Please ask for: Ms Iqraa Malik
Email: iqraa.malik@terraquest.co.uk
Telephone: 0121 234 1390
Our Ref: R/245/21/HH
Your Ref:
Date: 1st October 2021

Application for Planning Permission for Works or Extension to a Dwelling

Development: Erection of single, part two storey rear extension with balconies, installation of solar panel to side and alterations to fenestration following the demolition of existing rear conservatories
Location: 92 Sea Avenue Rustington BN16 2DL

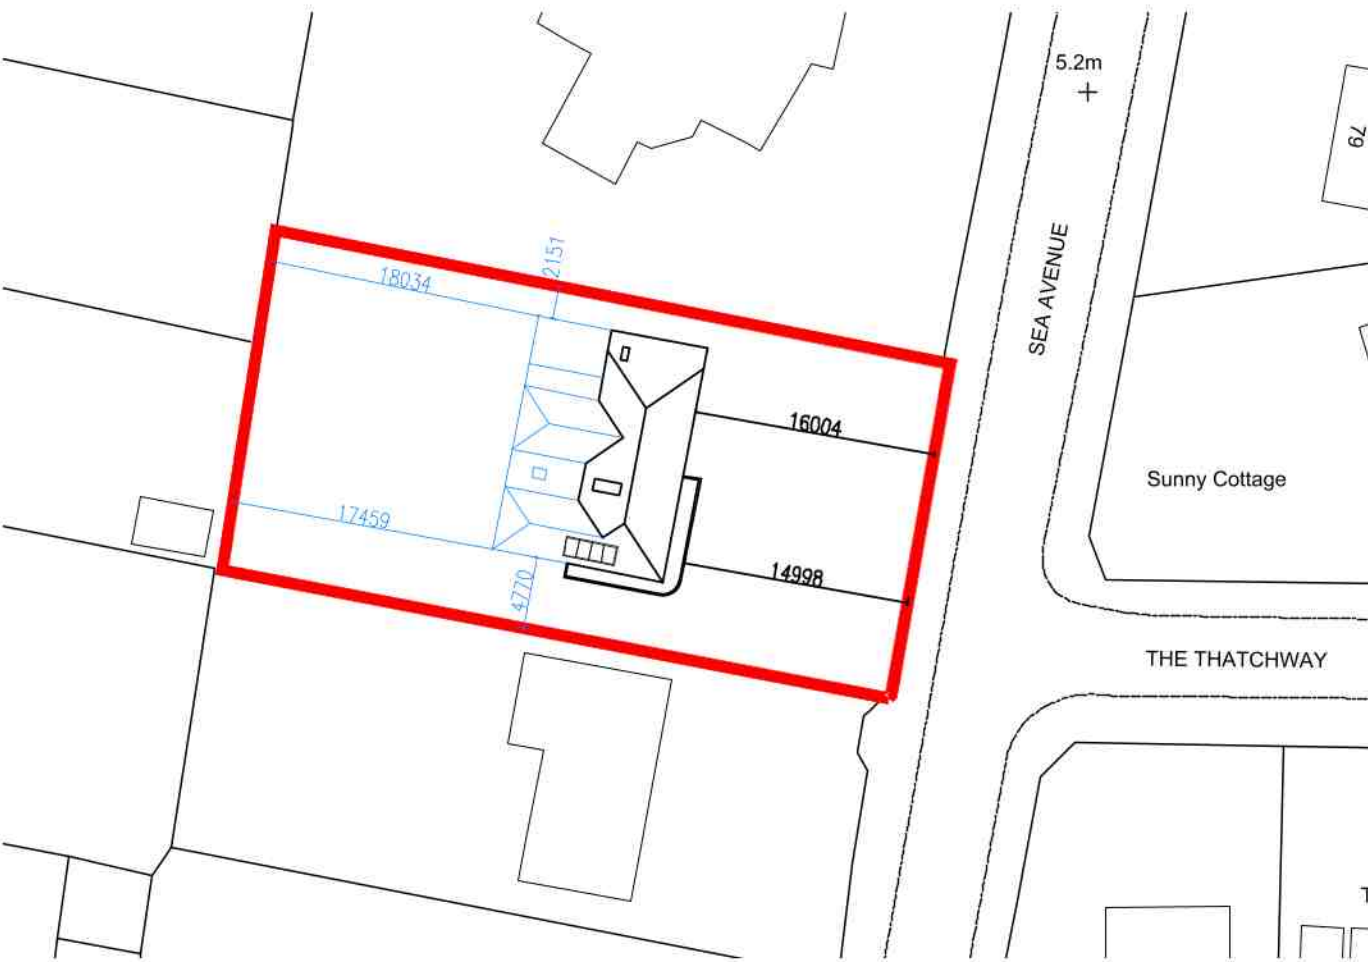
You are required to have dimensions from the proposed extension(s) to all site boundaries. Please amend.
